# HILLPOINTE APARTMENTS AT PETERSON CONSTRUCTION DRAWINGS - STORM SEWER PLAN & PROFILES

EPC STORMWATER REVIEW COMMENTS  
IN ORANGE BOXES WITH BLACK TEXT

CONSTRUCTION DRAWINGS  
STORM COVER & NOTES

CONSTRUCTION DRAWINGS  
 STORM PLAN & PROFILE I

CONSTRUCTION DRAWINGS
STORM COVER & NOTES

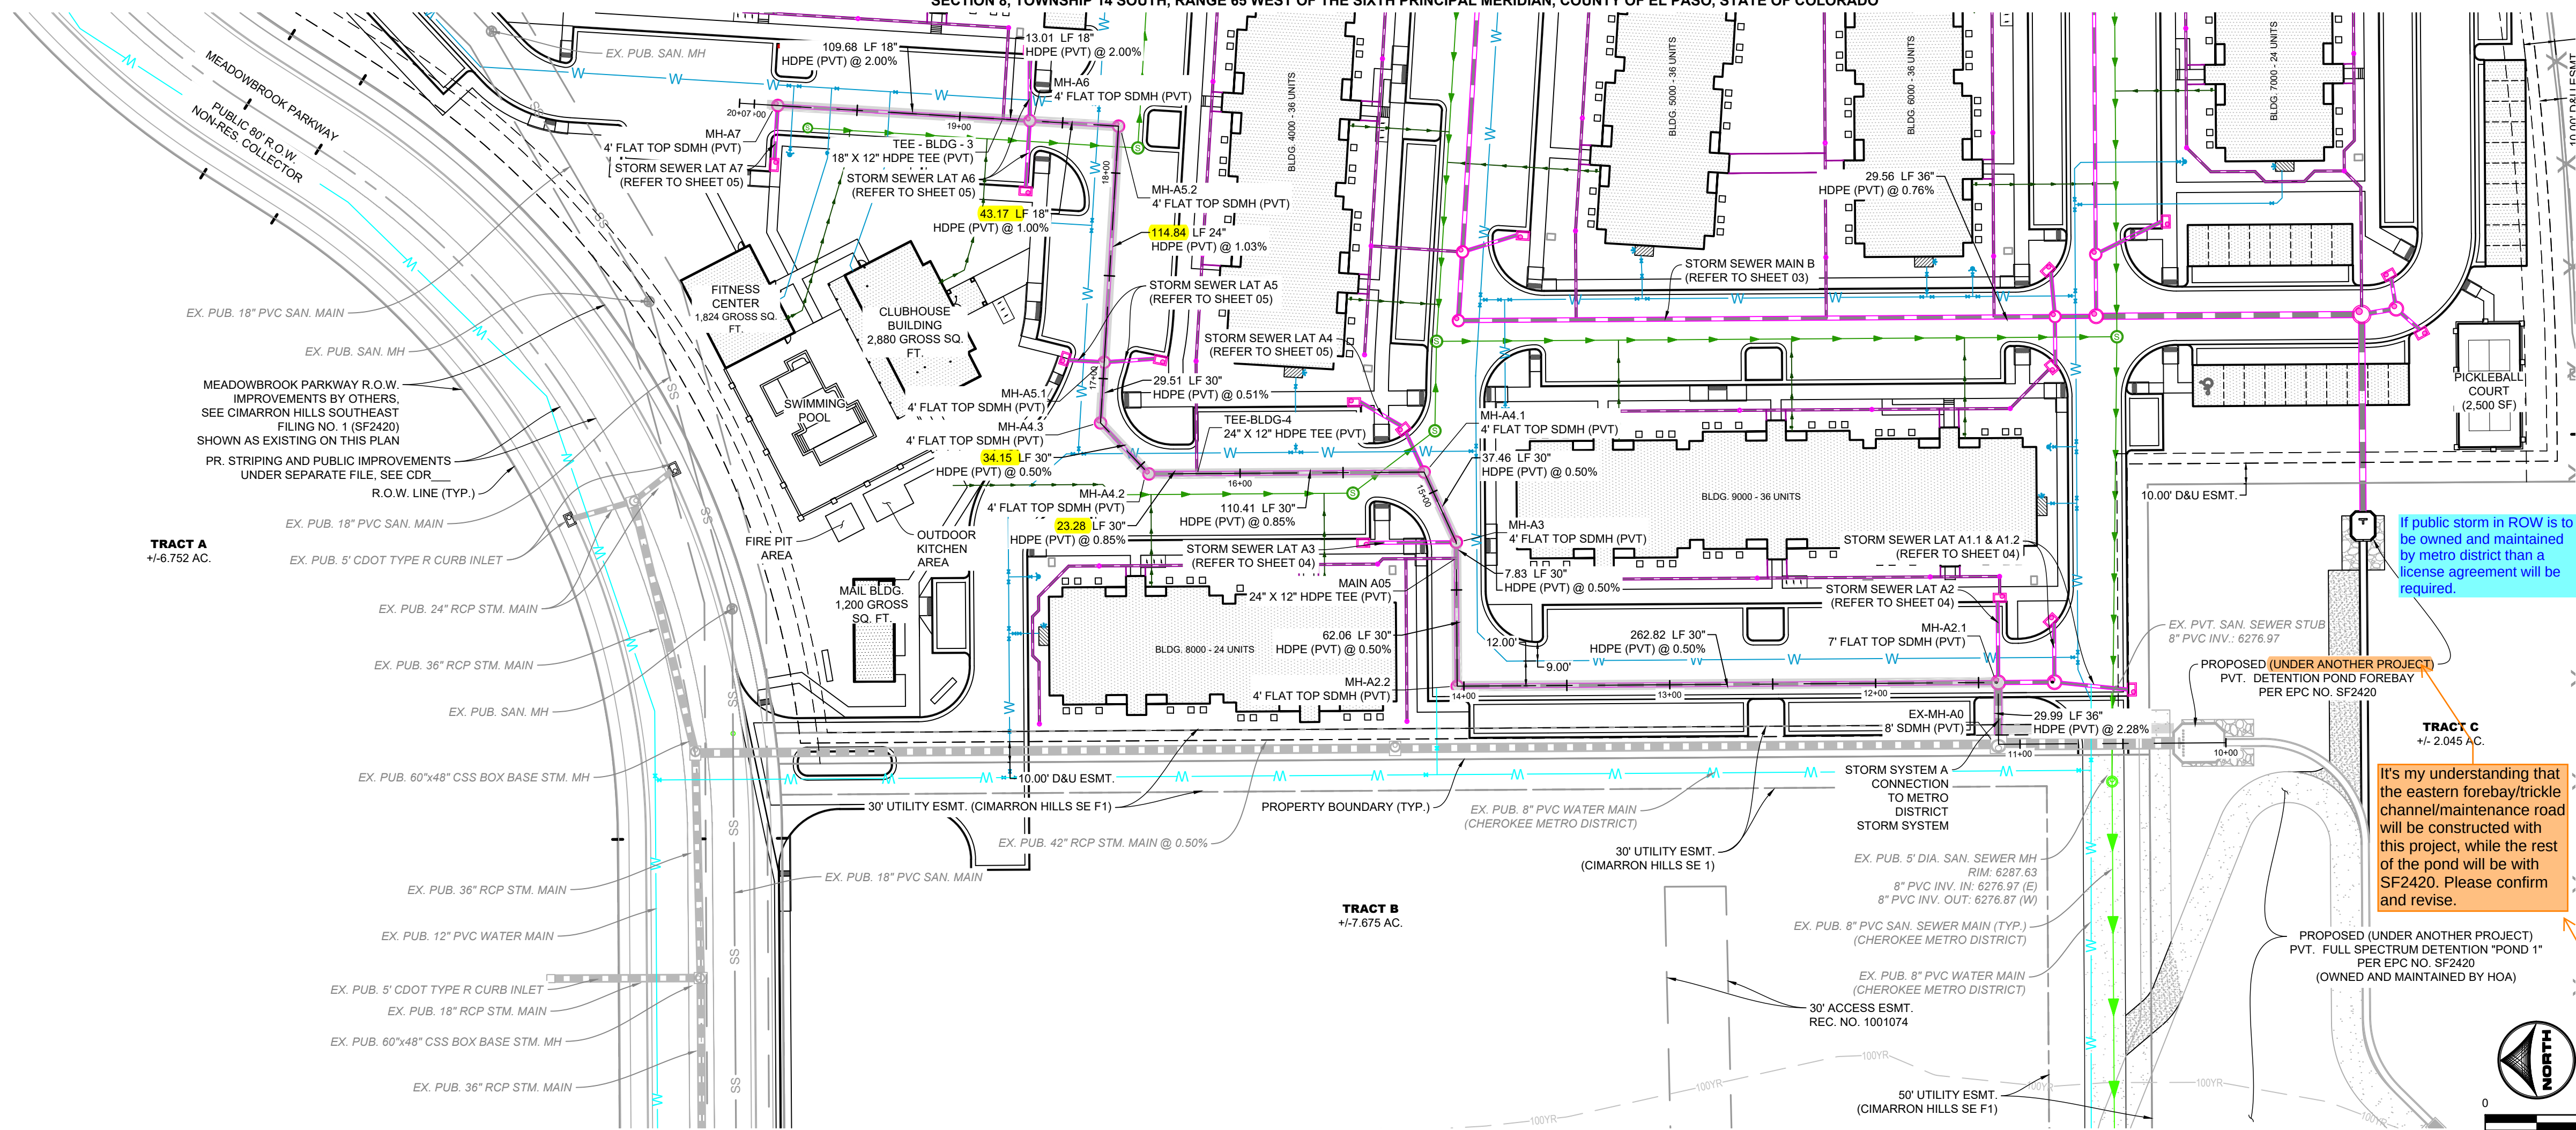
Add as Note 16  
- 16. El Paso County does not own and is not responsible for the underdrains or groundwater discharge systems shown on these plans and assumes no liability for water rights administration by approving these plans.

Since the pond will be constructed under another project, add the following condition of approval:  
Construction of any impervious surfaces (roadways, sidewalks, etc.) within the Hillpointe Apartments Site Development Plan shall not begin until Pond 1 and accompanying stormwater infrastructure required to direct flows from Hillpointe Apartments Site Development Plan to Pond 1 are substantially completed under CIMARRON HILLS SOUTHEAST MIXED USE FILING NO. 1. (SF2420) These areas require treatment from Pond 1.

Added.

Added.

PRIVATE STORM SEWER MAIN A (STA. 10+00 - 20+00)

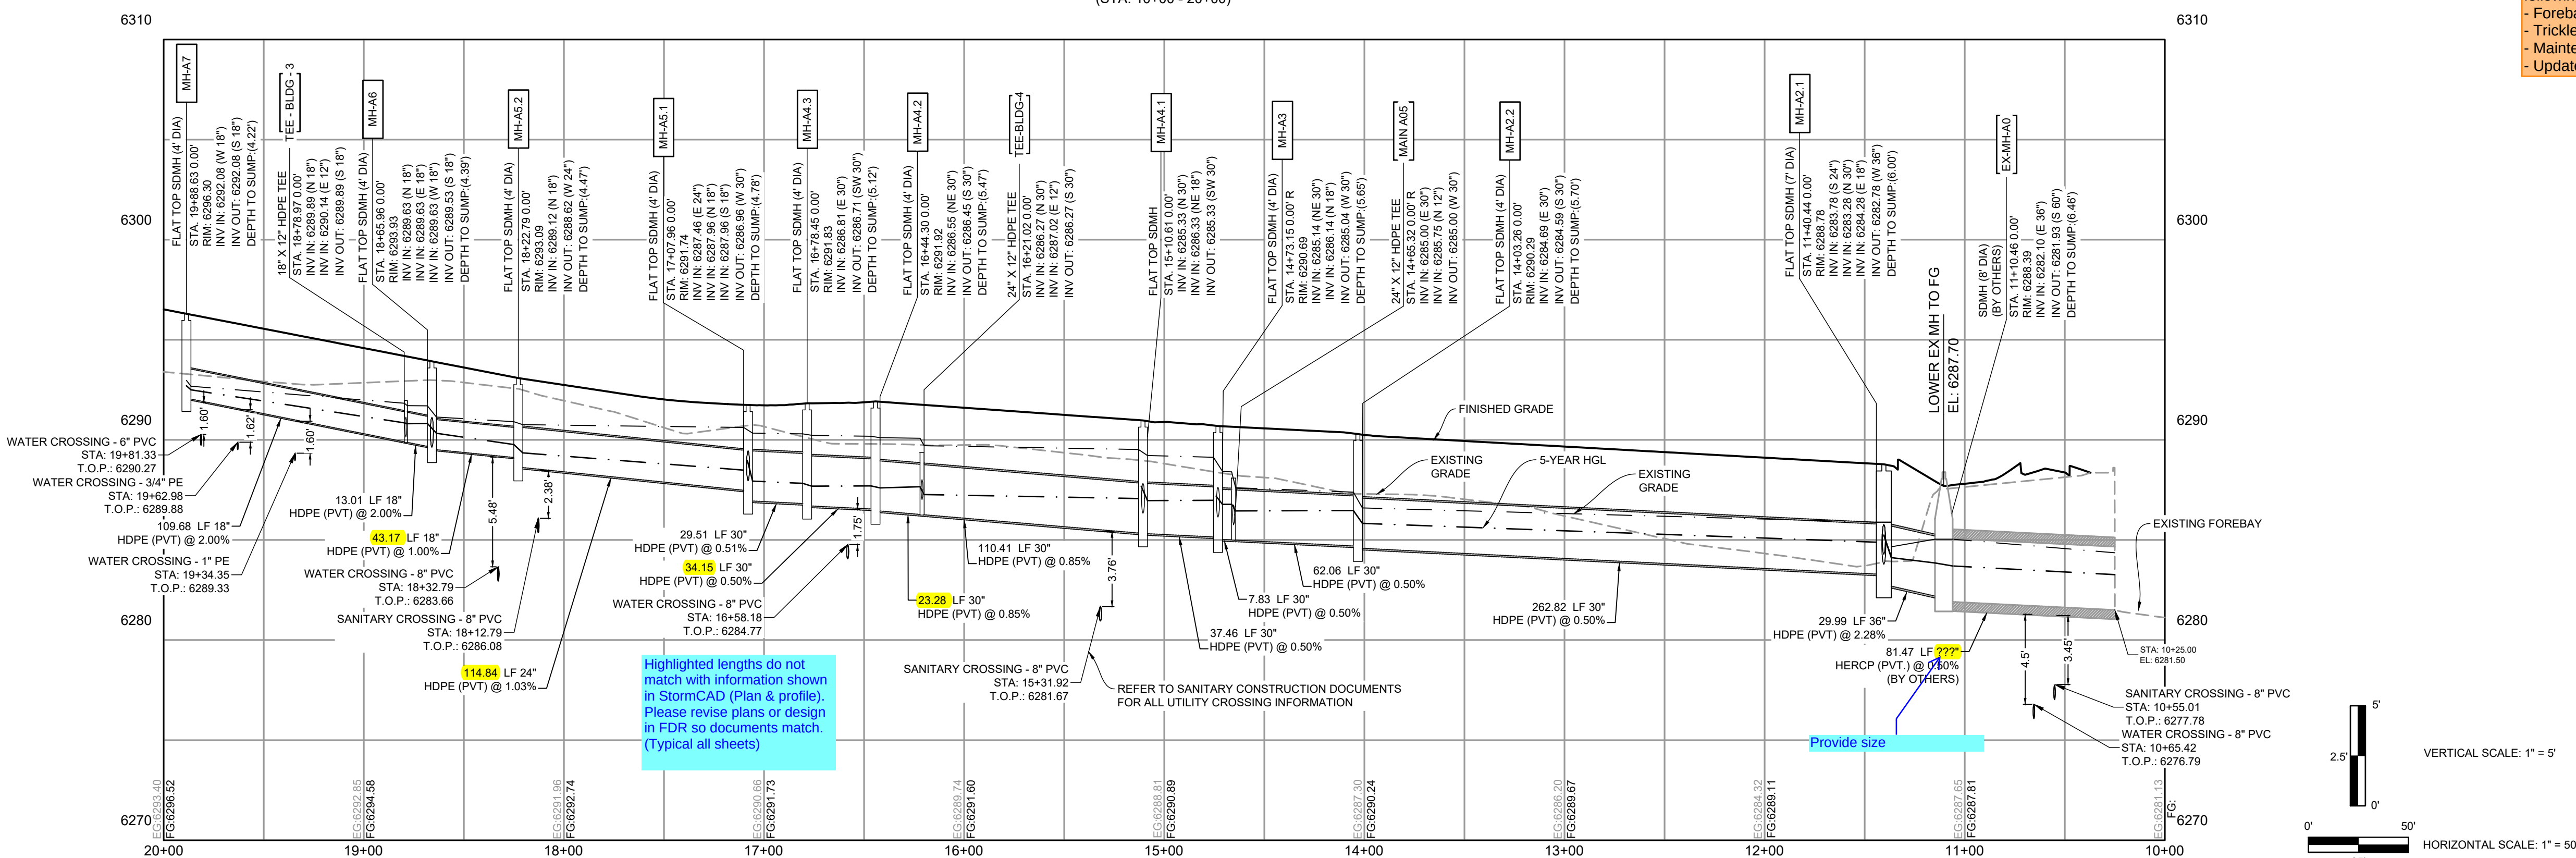
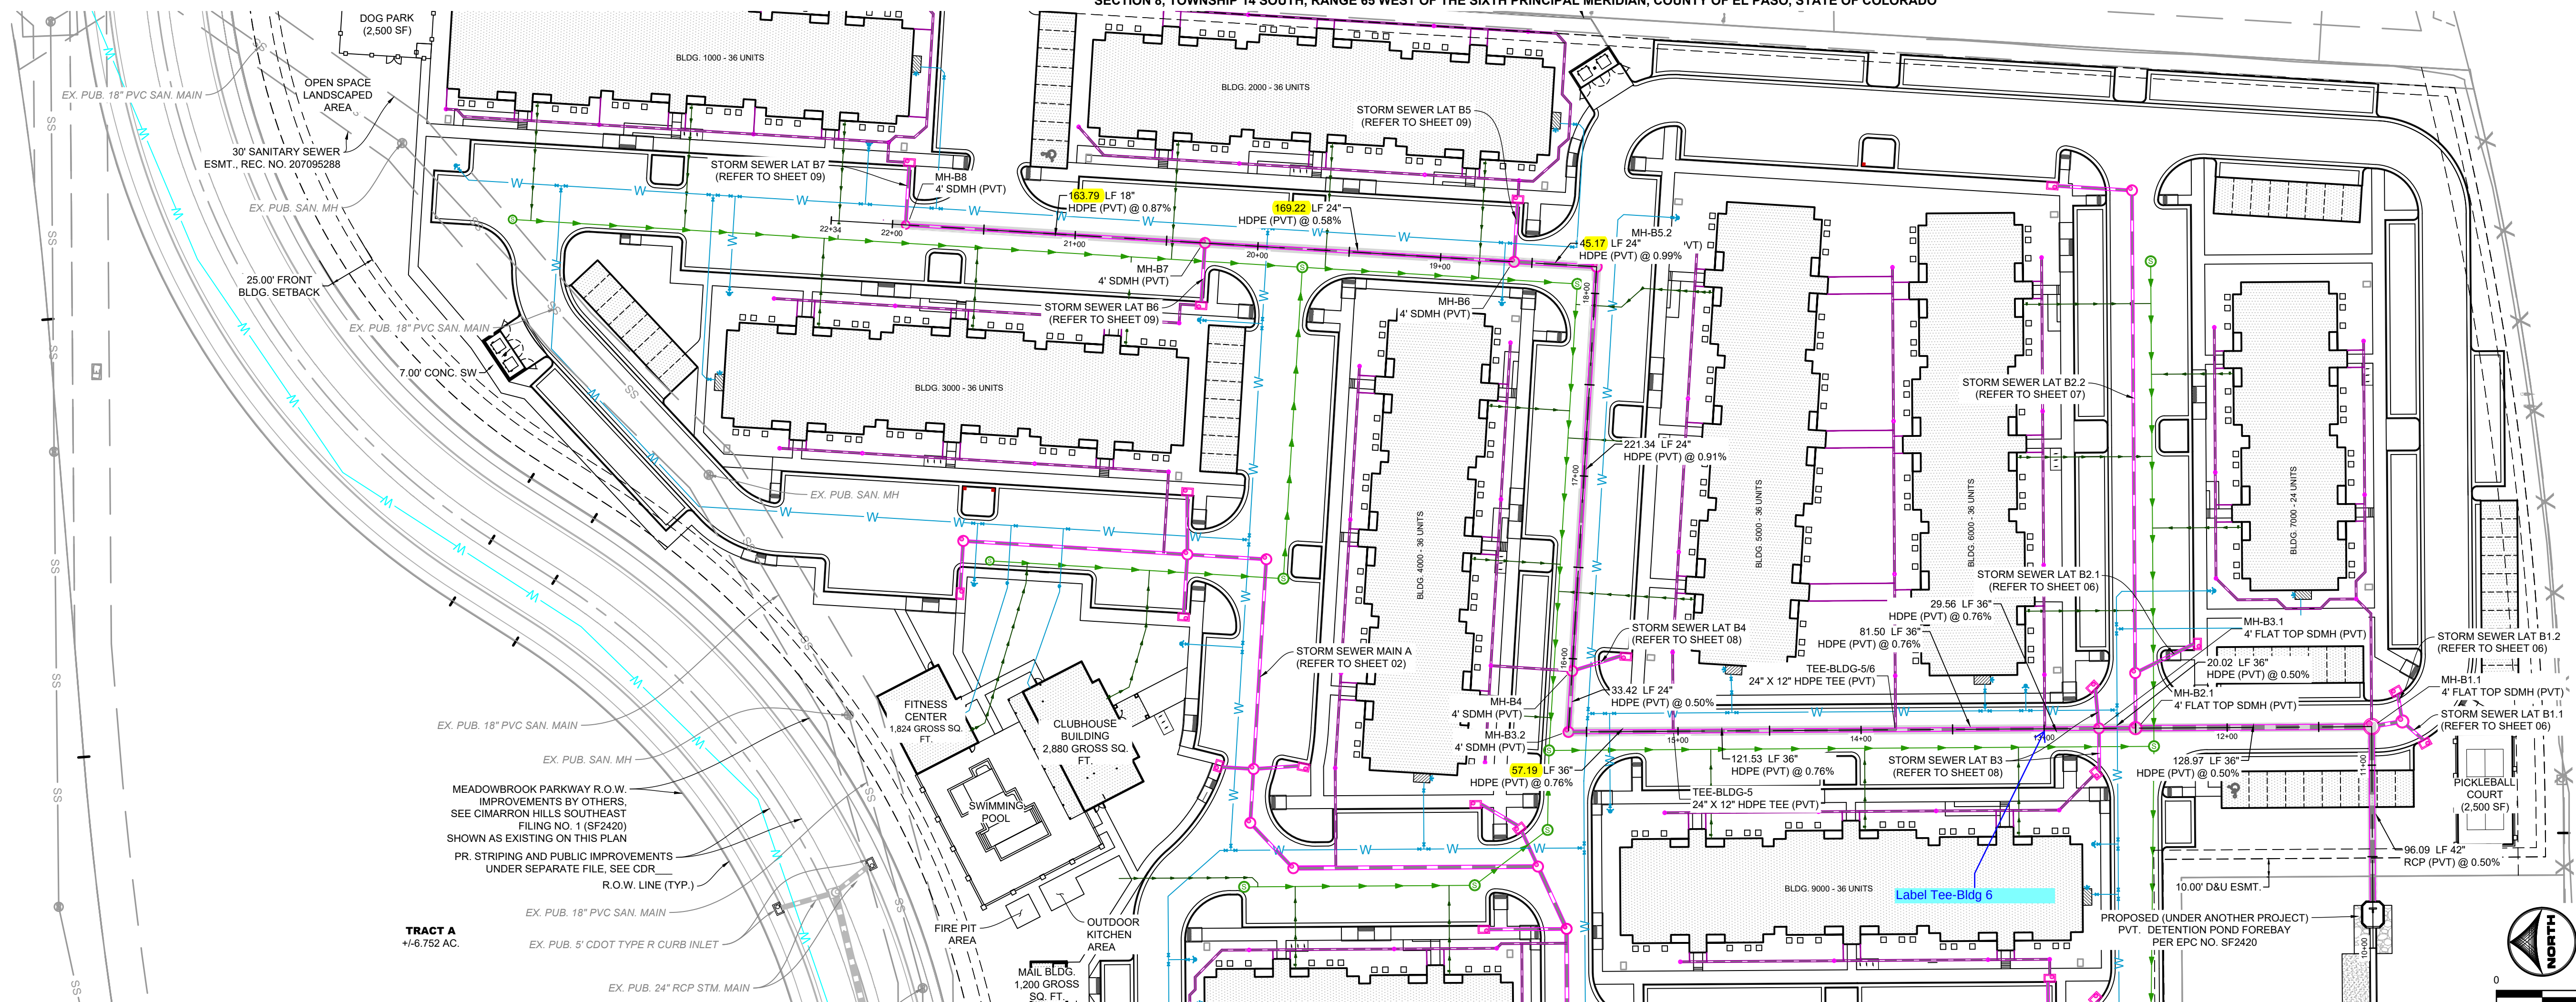
Per the TIS, "an eastbound right turn deceleration lane and westbound left turn deceleration lane at Site Access along Meadowbrook Parkway may also be required." Please add these turn lanes to the CDs and add a signing and striping plan for modifications to Meadowbrook Parkway.

ensure all culvert lengths are consistent with the drainage report. all of the lengths shown here are different from the report. (Typ)

include 5 and 100 yr HGL for all storm sewer

Changed to center-to-center lengths to match drainage report
